**Section 75W Modification Application No. 3 (Major Project MP 10_0105)
44-46 Walker Street, Rhodes**

This letter has been prepared by Urbis Pty Ltd on behalf of Waterpoint Site 1 Lessor Pty Ltd and Waterpoint Site 2 Lessor Pty Ltd in response to the NSW Department of Planning & Infrastructure (DoPI) request for additional information dated 22 October 2013, with regard to MP10_0150 MOD 3 (the Modification).

Elevations - BLDG D
South & West

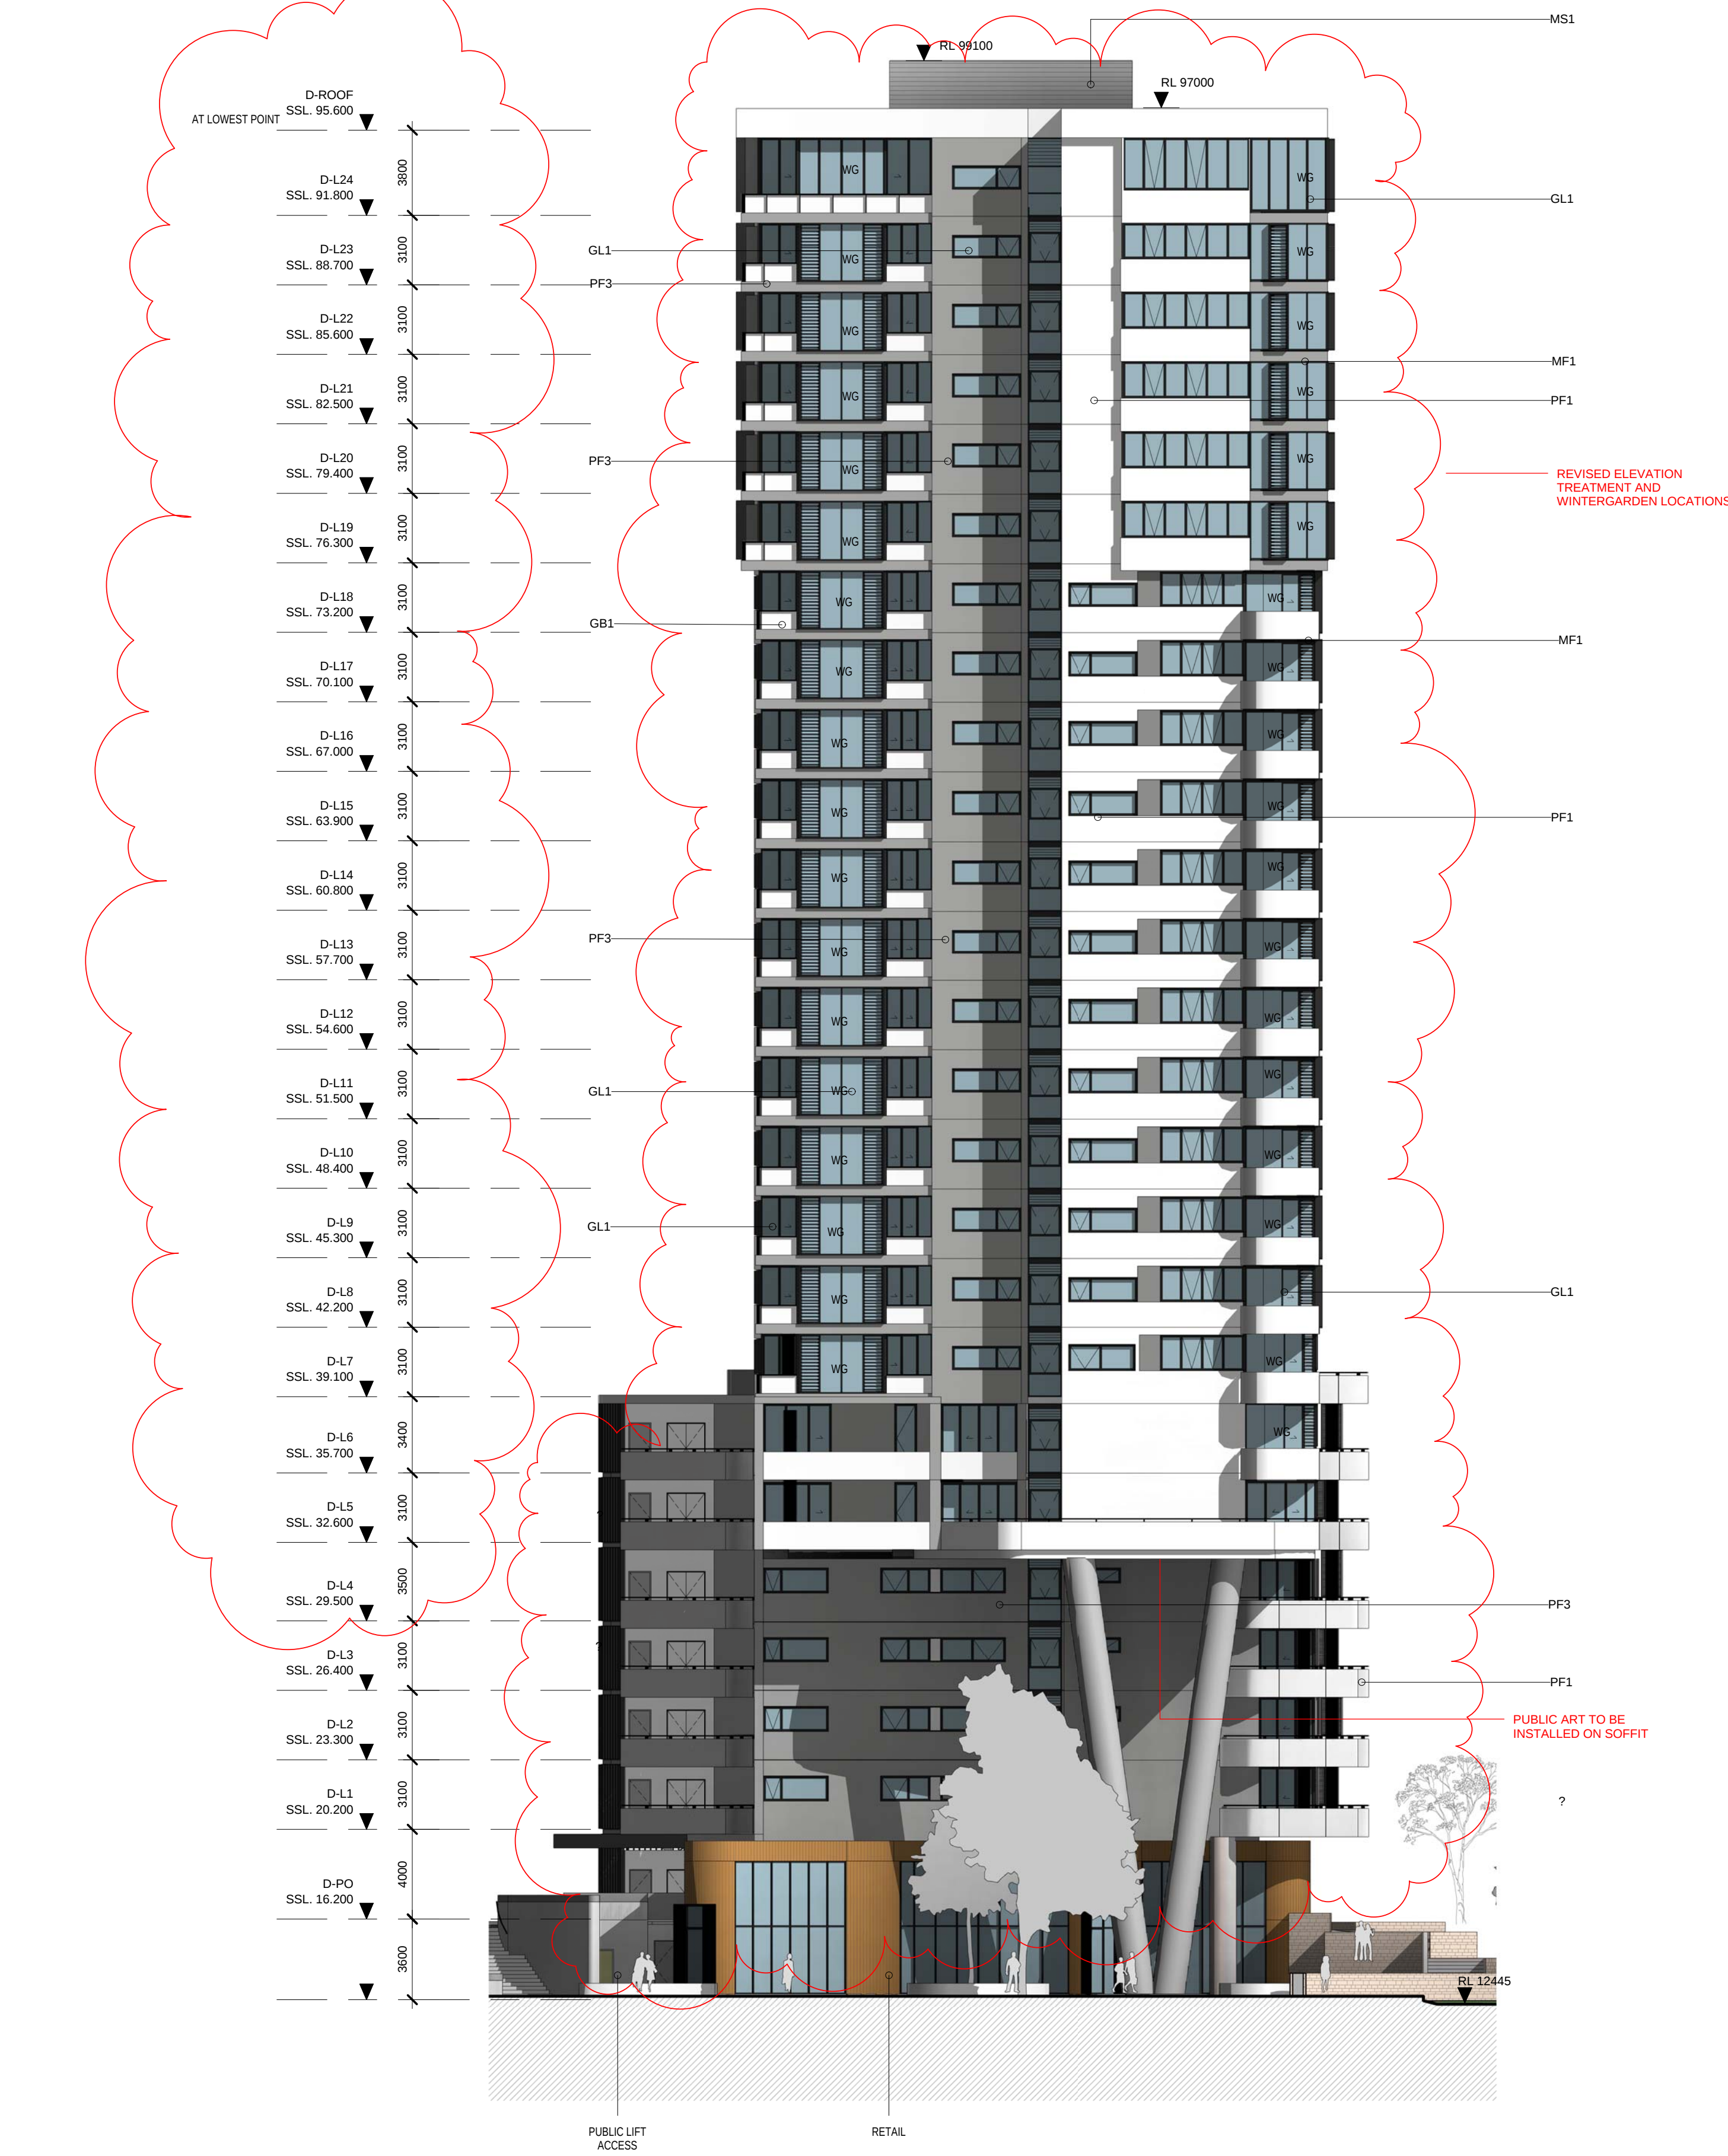
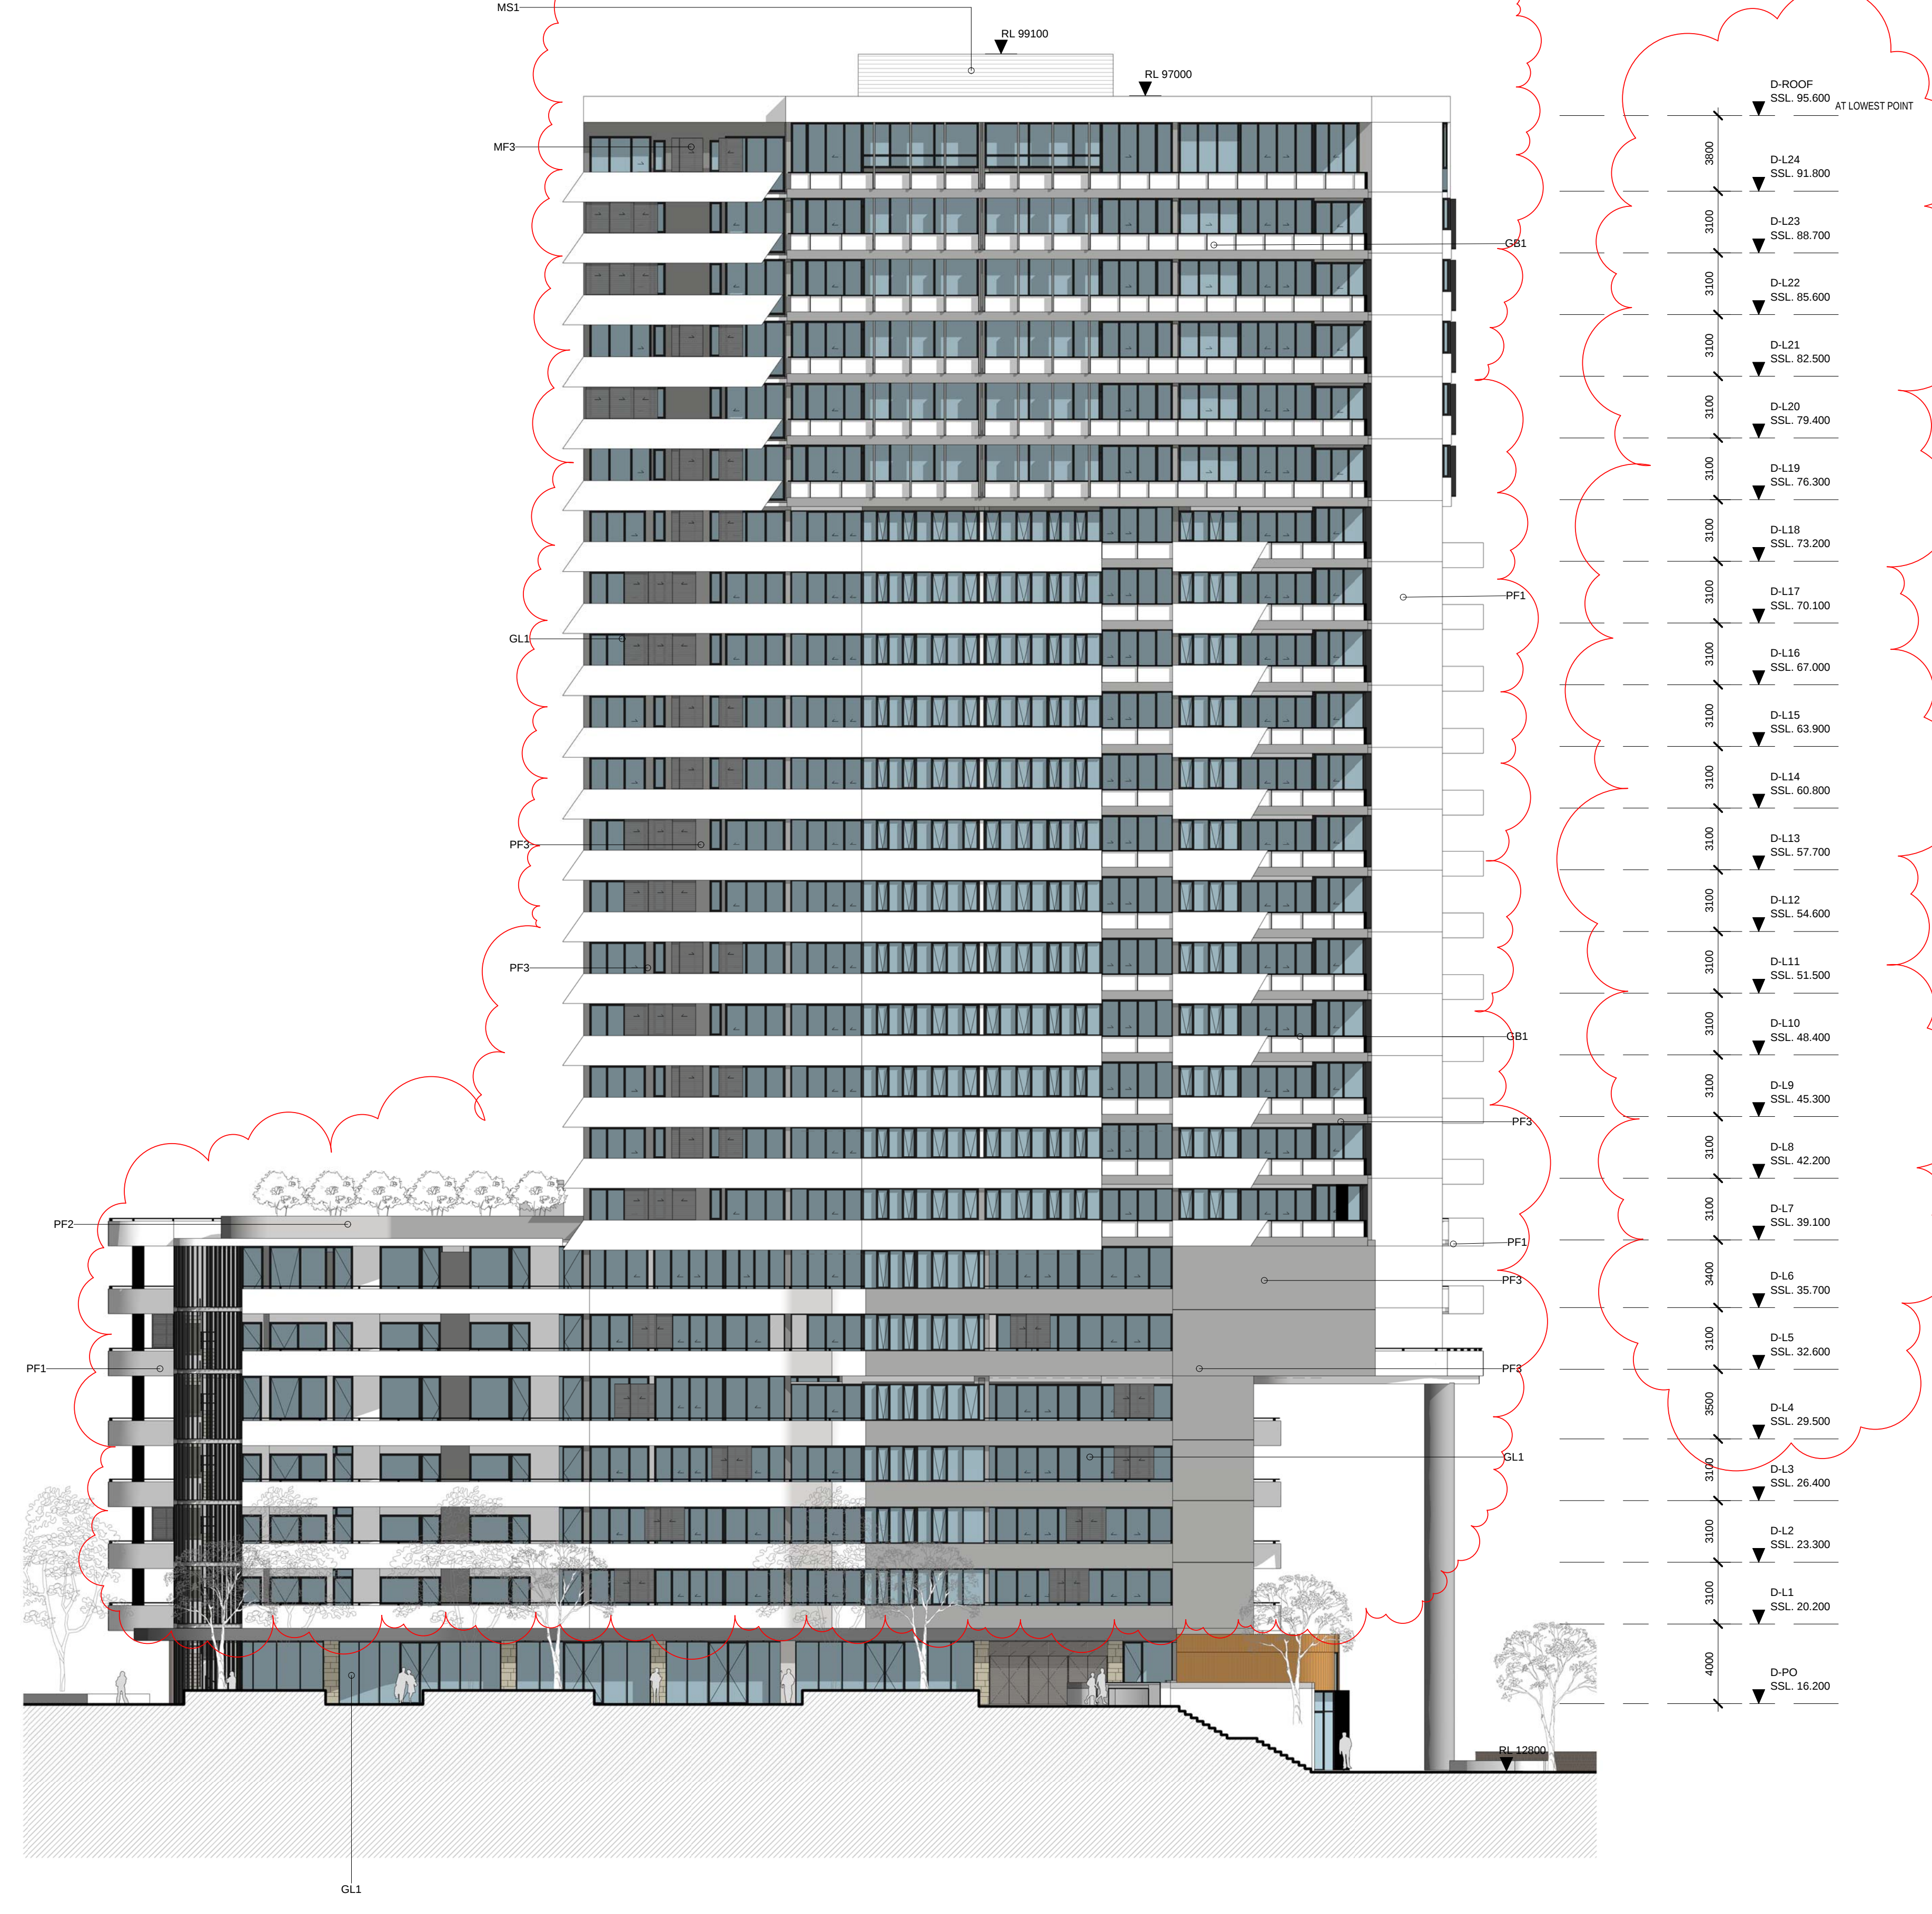
The approved maximum building height for Building D is RL 98.700 (82.5m). The maximum building height for the site under the CBLEP 2008 is 82m. The Project Approval exceeds the maximum building height for the site. The Modification seeks to increase the maximum Building D height to RL 99.300 (83.1m) to accommodate a revised roof plant configuration and the inclusion of an architectural roof feature at the top of the building. The proposed modifications represent a 0.6 metre increase to the Project Approval building height. This is discussed in further detail below.

The approved height of the roof plant is RL 98.700 (82.5m). The Modification proposes a minor increase in height of 0.4 metres to the top of the roof plant, resulting in a height of 82.9 metres. There is no proposed increase to the roof plant footprint.

- The maximum building height for the site is 82 metres.
- The maximum building height approved under the Project Approval is 82.5 metres.
- The maximum building height for the Modification of Building D is 82.9 metres.
- The proposed building height represents a 0.5% increase to the building height approved under the Project Approval.

- The approved Building D height is 82.5 metres. This equates to a minimal 0.6% increase to the CBLEP 2008 maximum building height of 82 metres.
- The Modification seeks to increase the approved building height by 400mm (82.9 metres) to accommodate the revised roof plant arrangement. There is no increase to the number of building storeys. This will equate to a 0.5% variation to the approved building height and result in a 1% (900m) variation to the CBLEP 2008 maximum height limit.
- The additional height is located on the roof plant only and is setback from all four building edges. The proposed architectural roof feature will obscure and reduce the visual impact of the roof plant when viewed from Parramatta River to the east.
